PPR-18-053

February 13, 2019

**RE: Lot 3, Beckett at Woodmen Hills, Filing No. 3
El Paso County, CO
Drainage Letter**

Selected Drainage Map from Beckett at Woodmen Hills Filing No. 3 Drainage Report

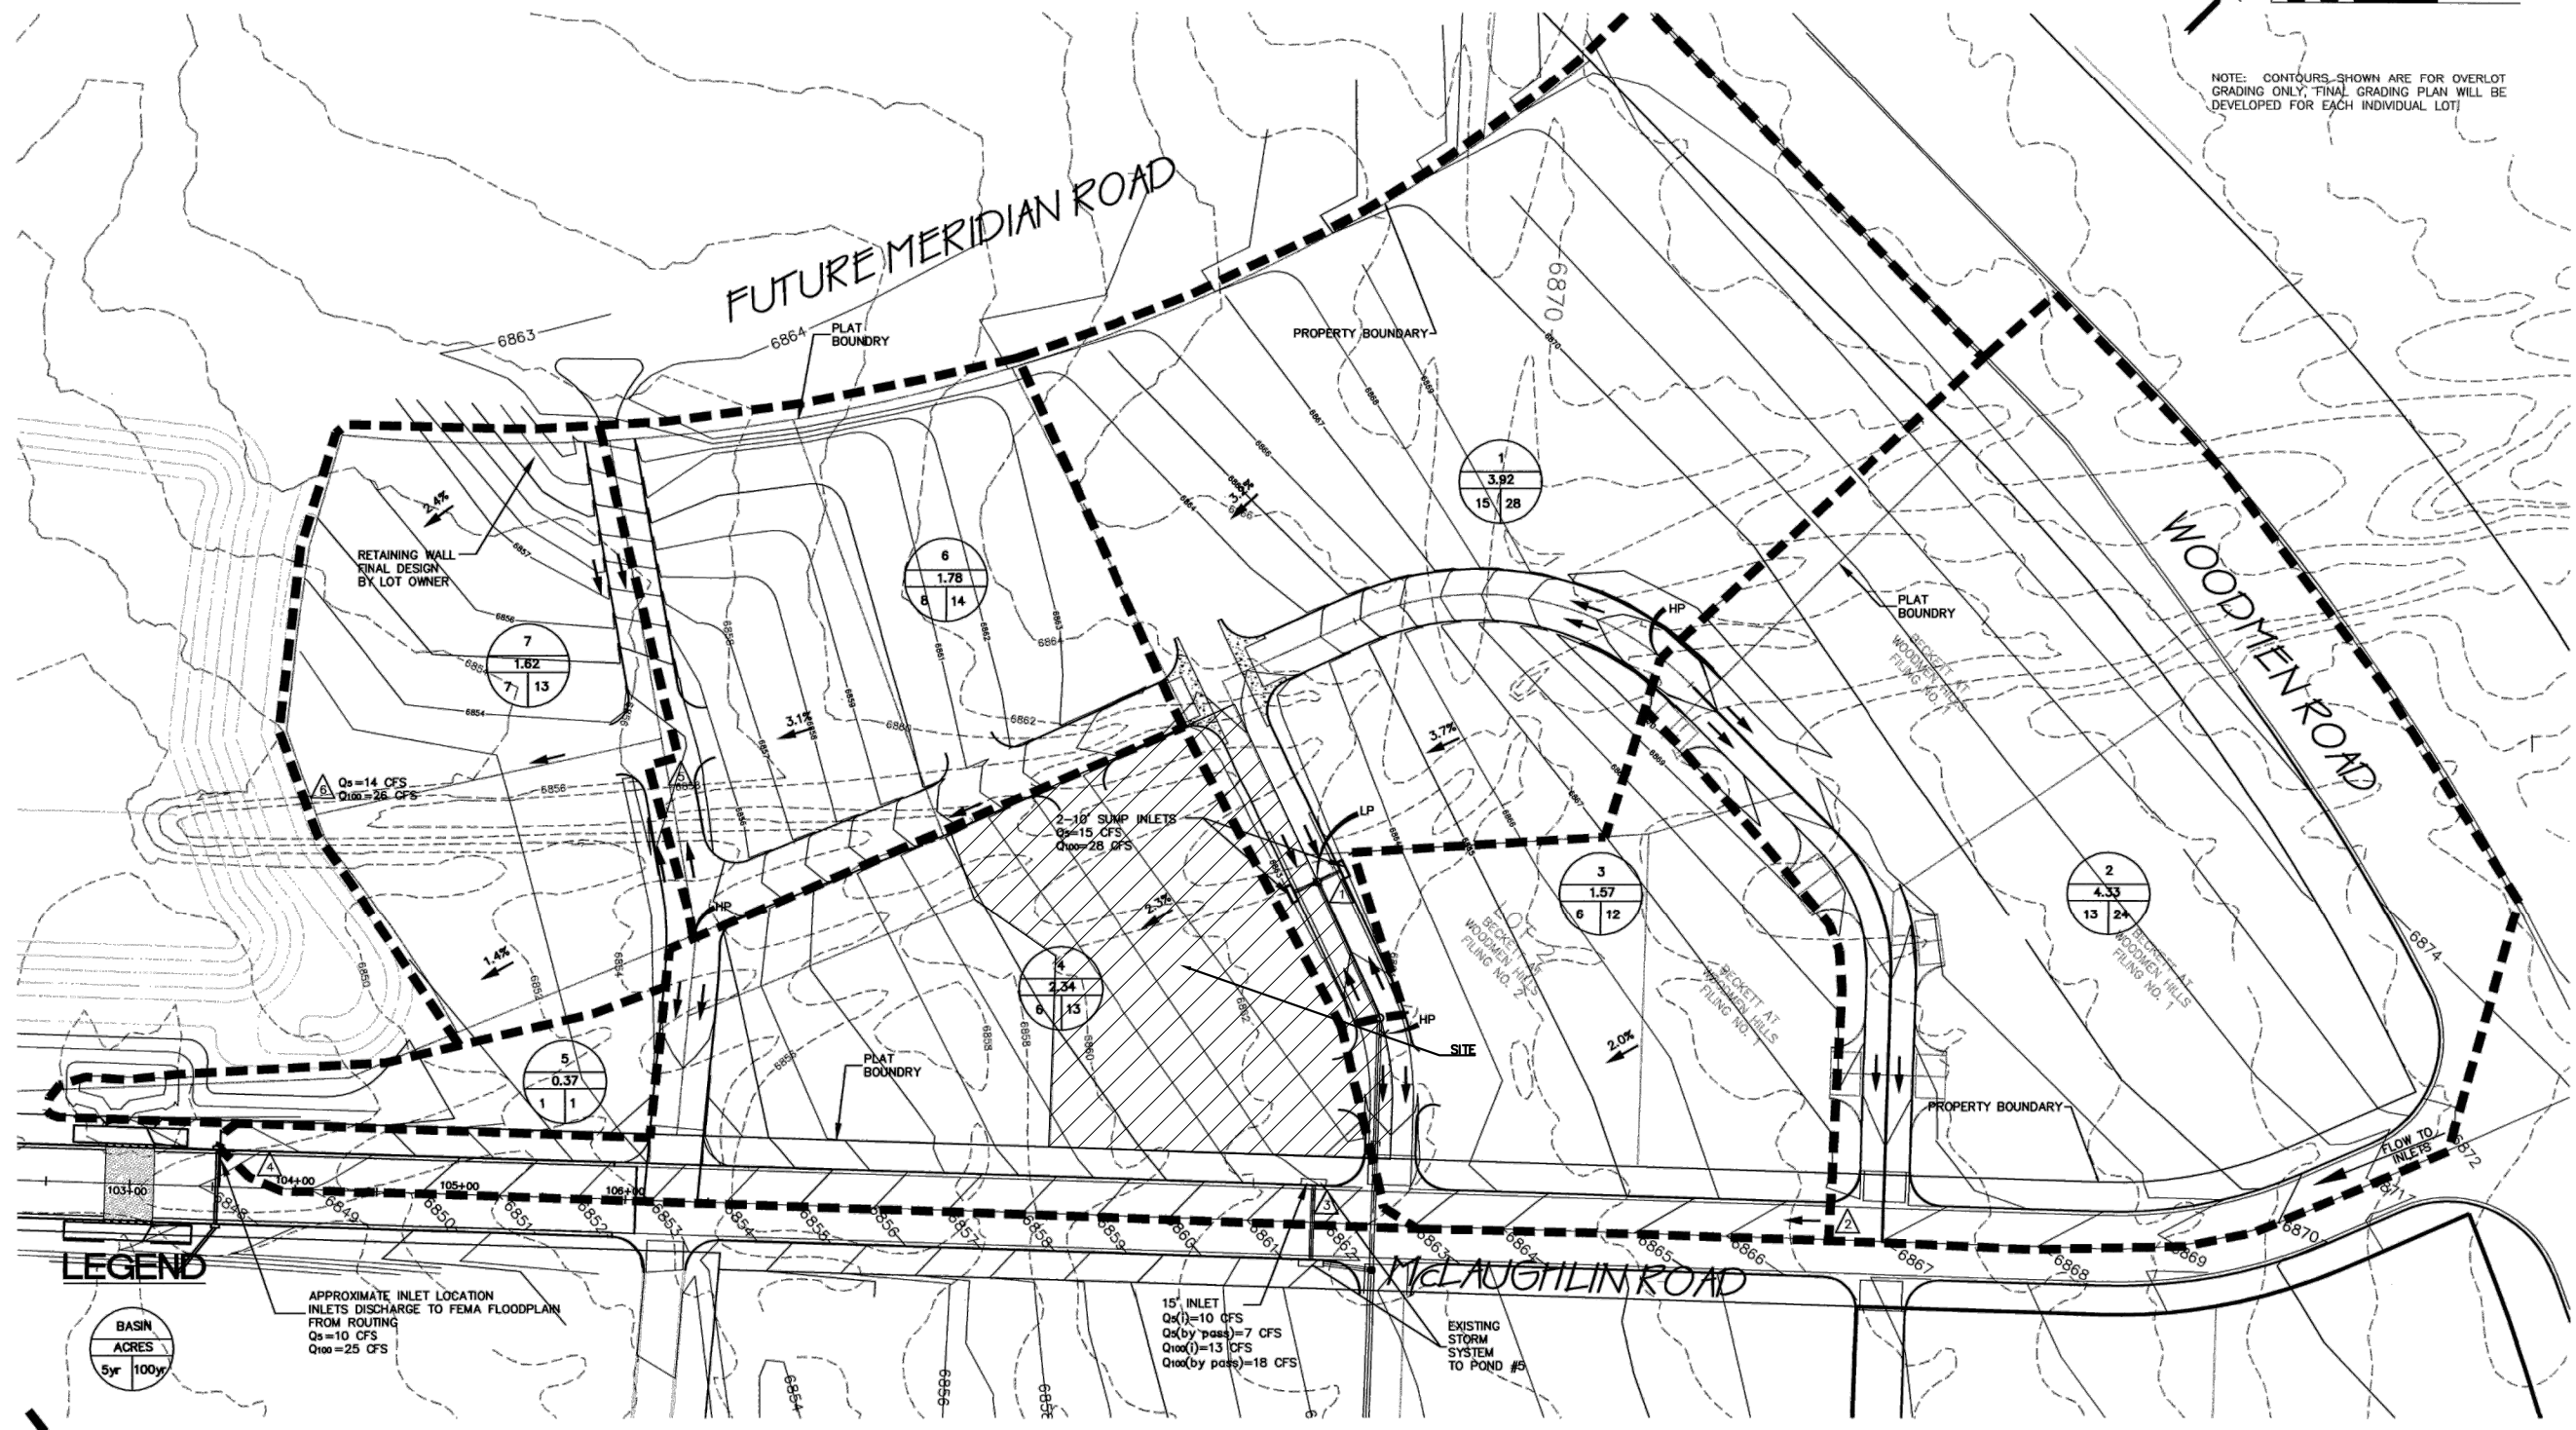
Identify in the report where 5 and 100 year detention is provided for, is this facility constructed and accepts flow from this project.

Statement added regarding Regional Detention Pond #5.
